Project Number: 640029.000
Project Name: North Sydney Public School
Date: 19 November 2021
To: Tarini Pathak, Turner & Townsend
From: Alex Krickx, Integral Group

Re: NSPS Roof Layout Update + ESD Targets

Figure 10: Amended PV layout on the roof of Building J (Source: Fulton Trotter)

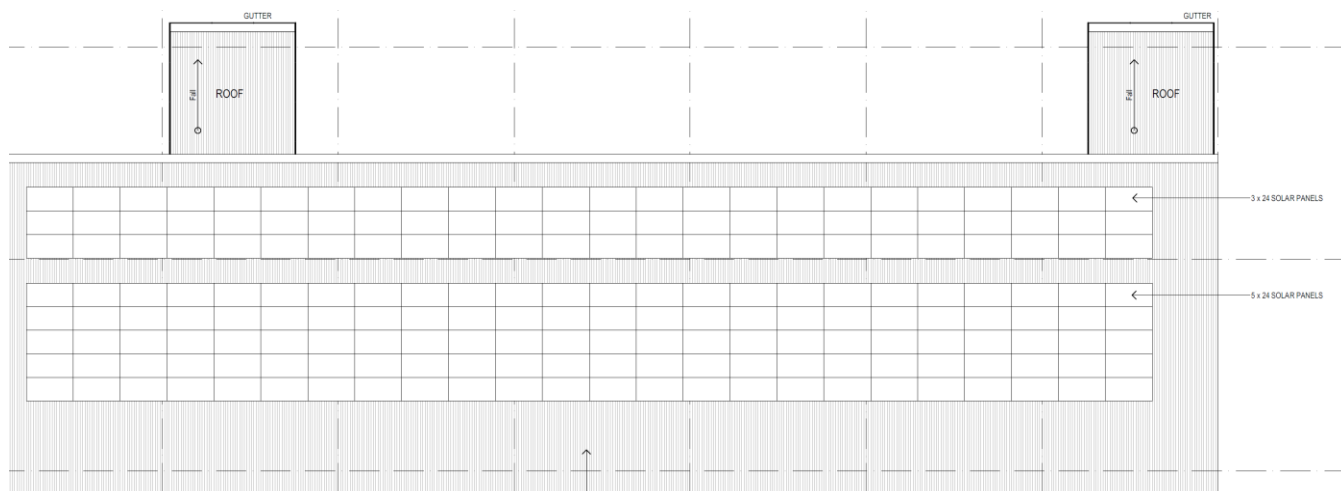
Based on the updated roof layouts provided, there are currently 196 PV panels shown on the project roof. We were not provided a panel description, and have conservatively assumed 300 Watts per panel, which equates to a 58.8 kW System.

This system size is substantial and supports the ESD ambitions of the project. We do not see any changes from the initial ESD targets based on this layout.
